## **A63 Castle Street Improvement, Hull**

### **DCO Documents Errata**

Revision Record						
Rev No	Date	Originator	Checker	Approver	Status	Suitability
P01	10 May 2019	A Sadler	C Stott	J McKenna	S4	Shared

3 6.2 Environmental Statement Volume 2 Figure 10.2 (APP-036)

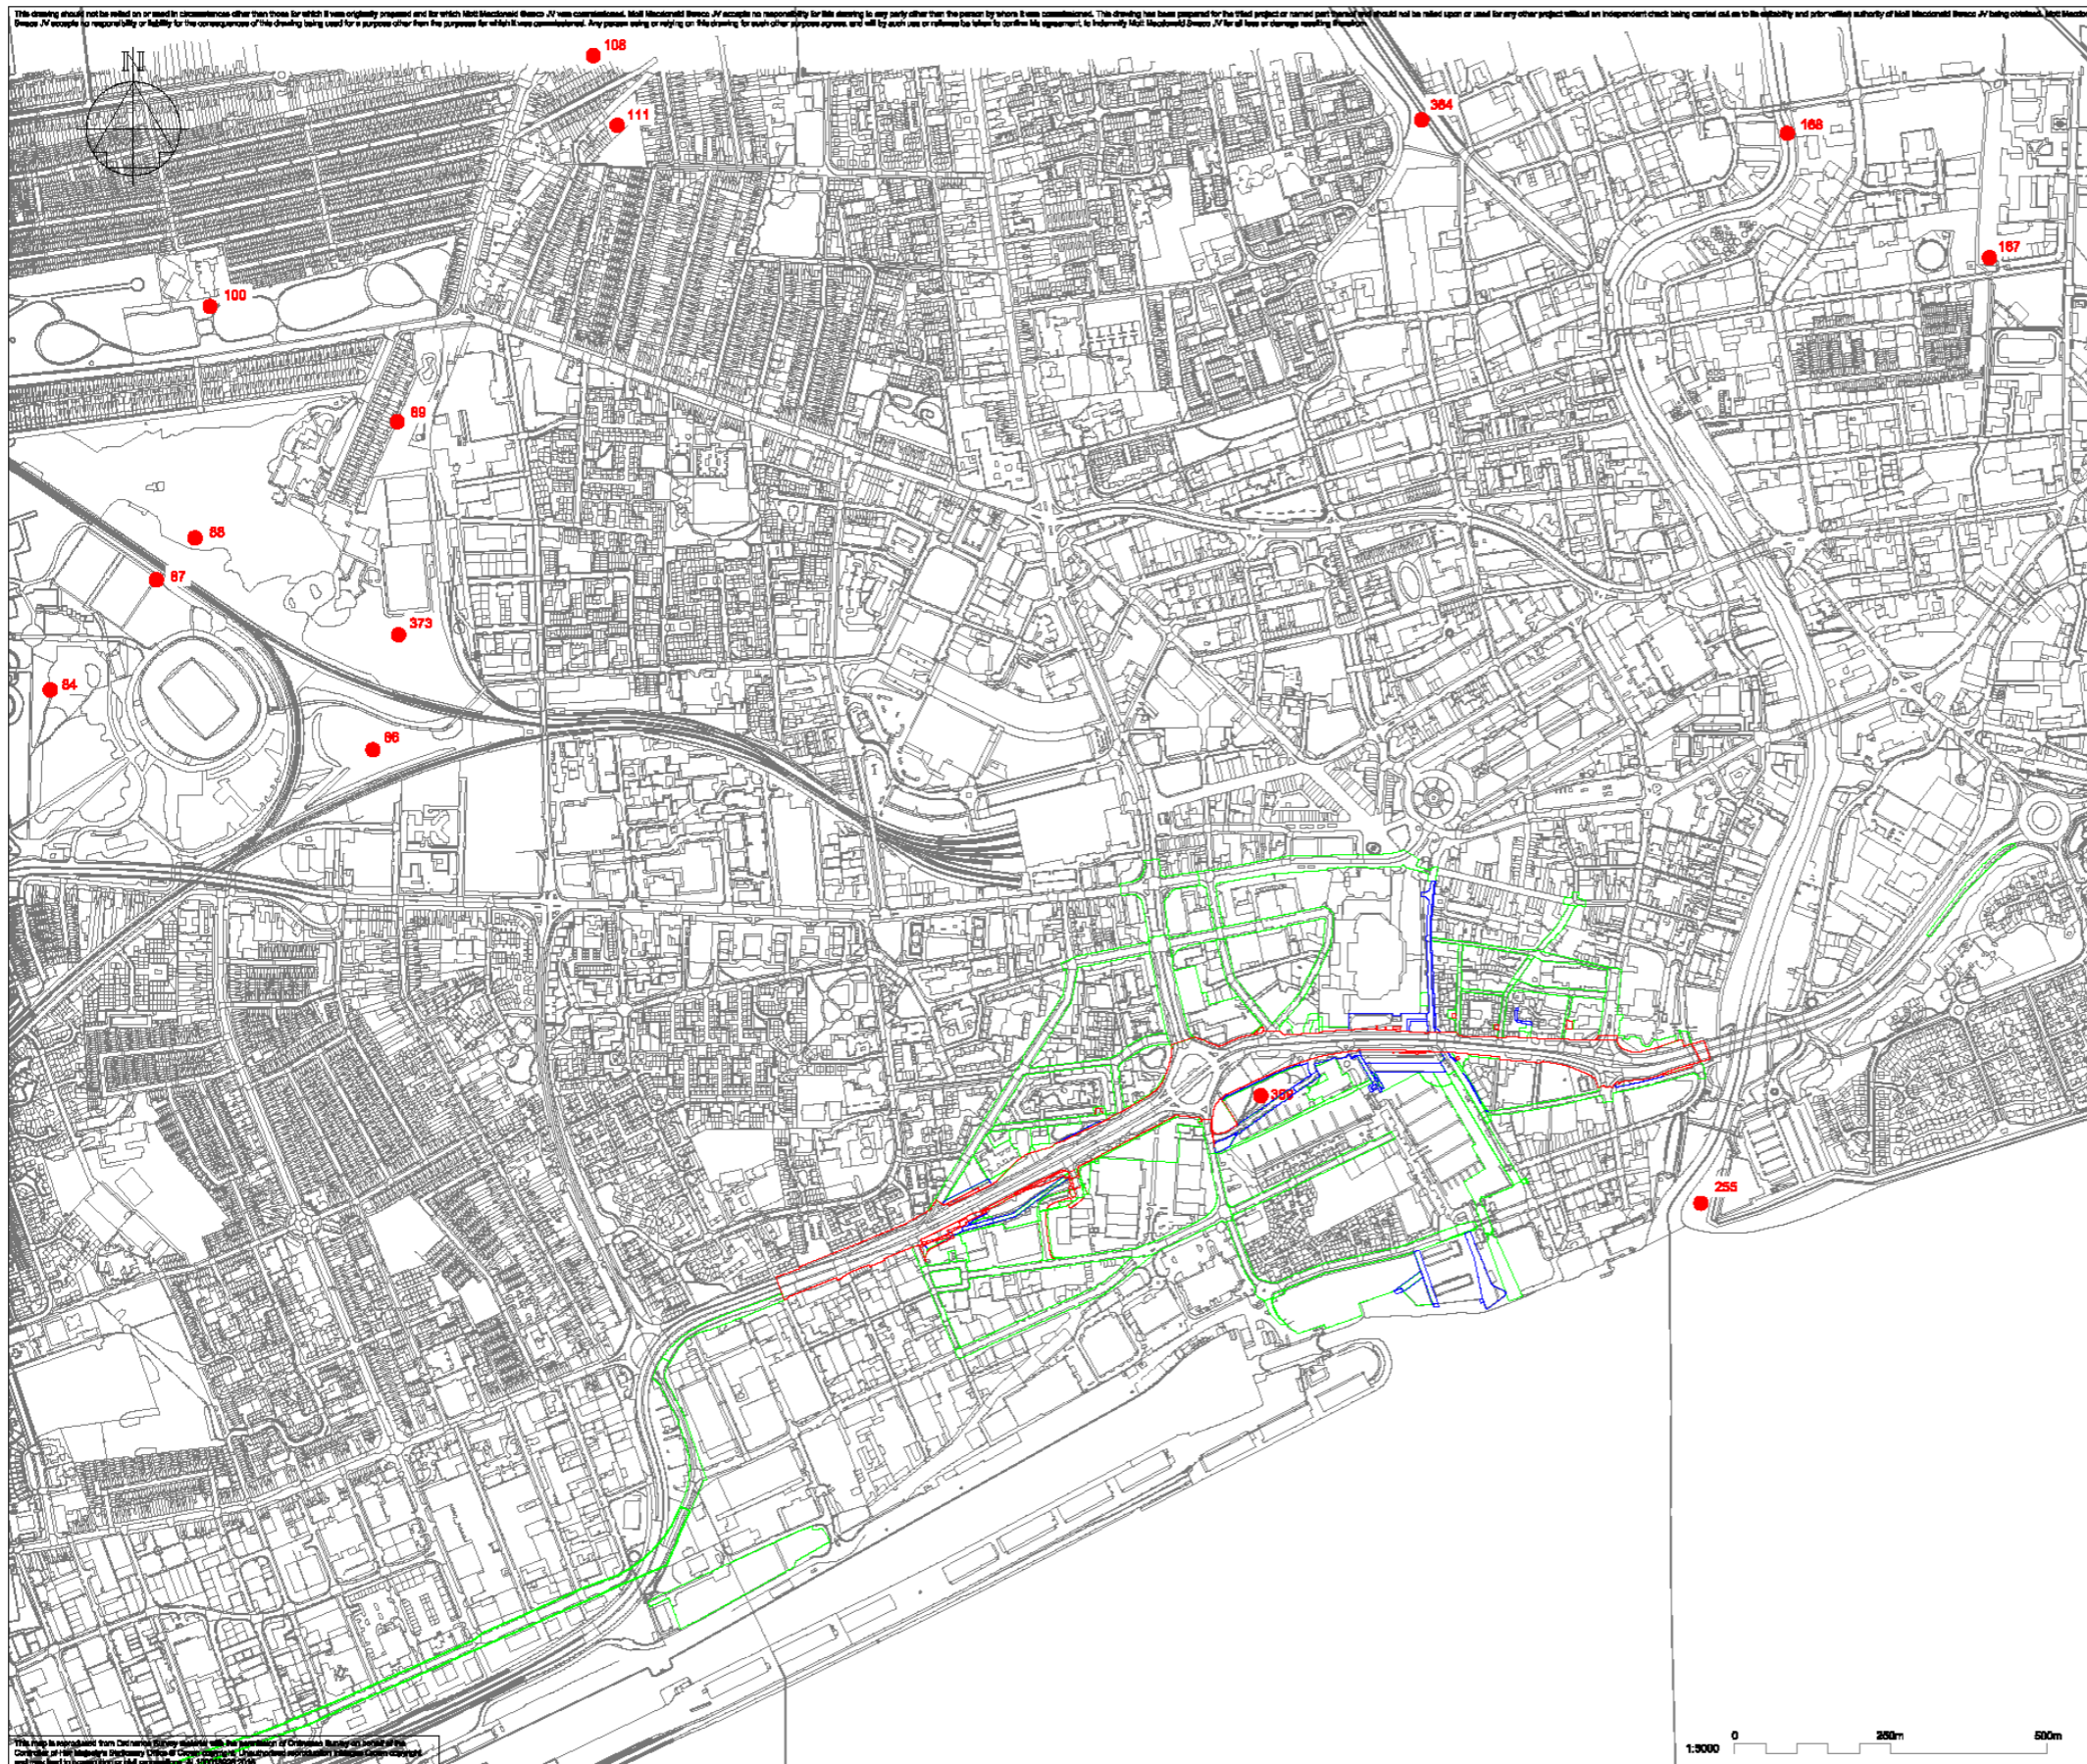
3.1.1 Replace ES Volume 2 Figure 10.2 Non-statutory designated sites (APP-036) with the new Figure 10.2 Non-statutory designated sites as below. Changes are as follows:

- The key has been replaced.
- Sammy's Point Site of Nature Conservation Interest (SNCI) has been added to Figure 10.2 as the mudflats are 250m from the Site boundary.
